DEVELOPMENT REVIEW BOARD – SPEED MEMO

DRB CASE NO/PROJECT NO: 1006681

Sketch Plat

Development Review Board 7/25/07 Agenda Item #19
Sketch Plat: Tract D, Schwartzman Packing Company
Subdivision

**SITE DATA - 121 Room Value Place Hotel**

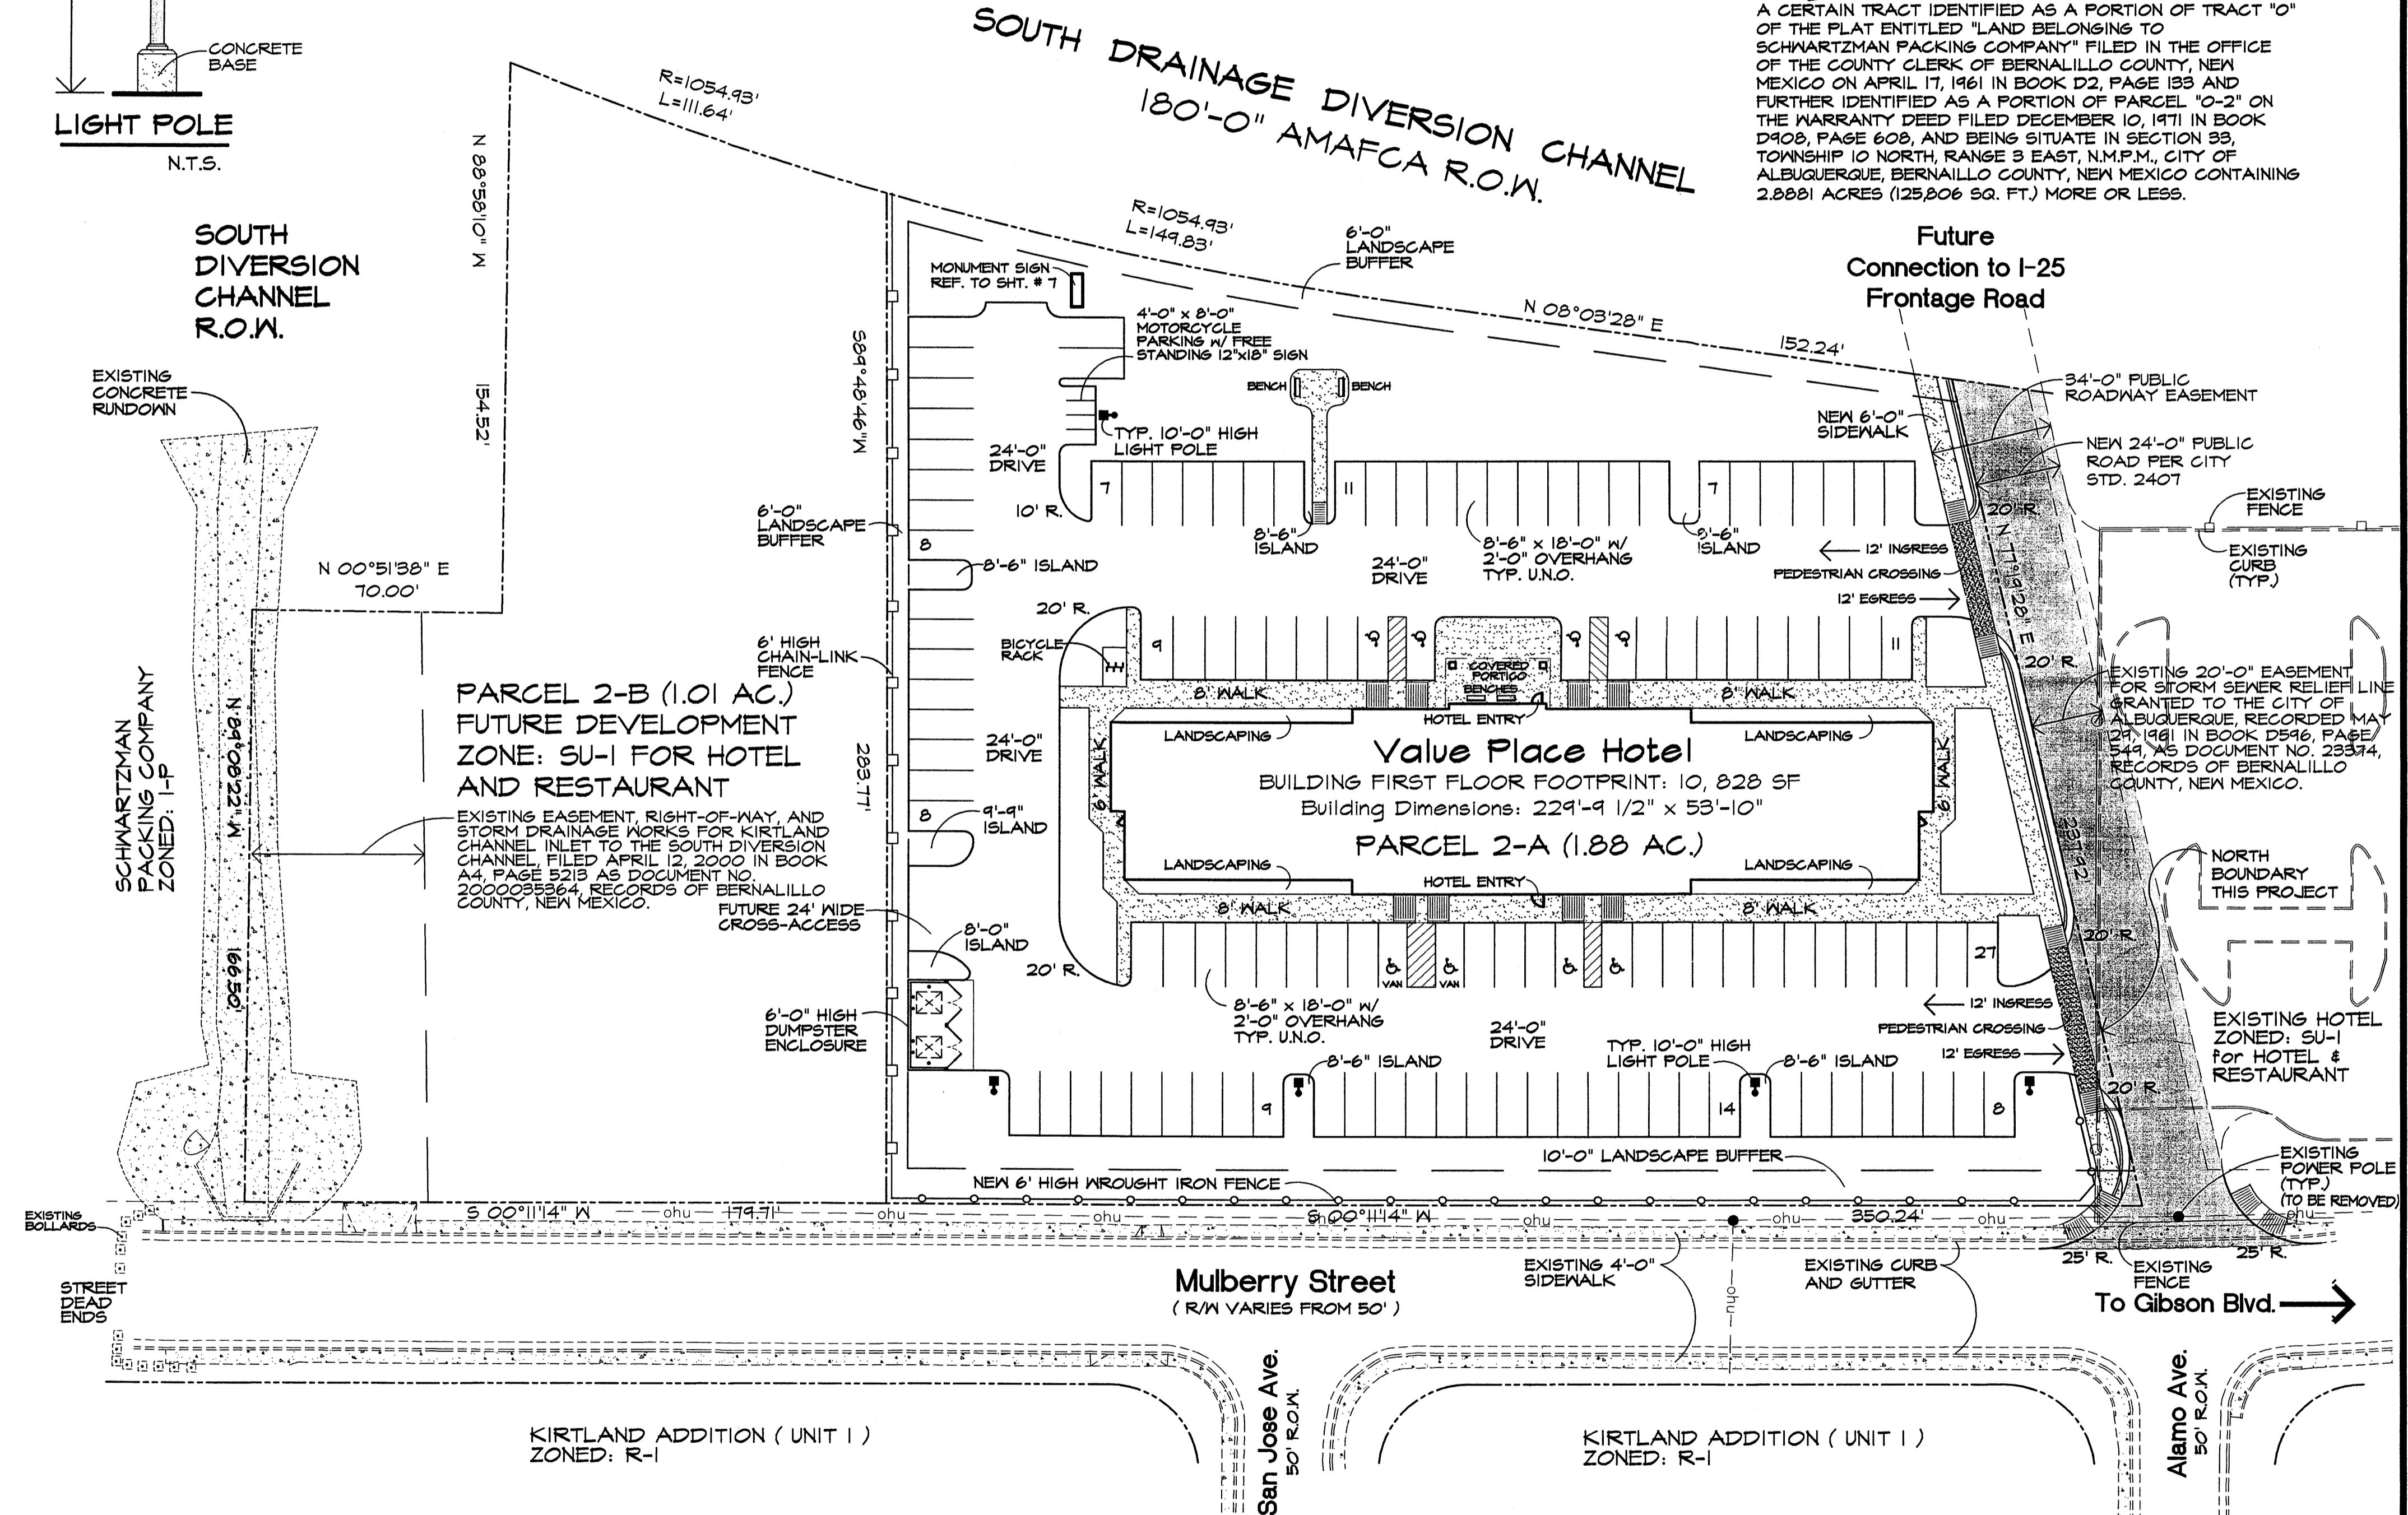
<u>No.</u>	<u>Comment</u>
1)	A copy of the EPC conditions will be required to evaluate infrastructure list requirements.
2)	Was a TIS required?
3)	A copy of the 34' public roadway easement will be needed.
4)	The previous site plan show sidewalk and an asphalt trail.
5)	Is the lot being replatted? Where is the 24' cross access to the south?
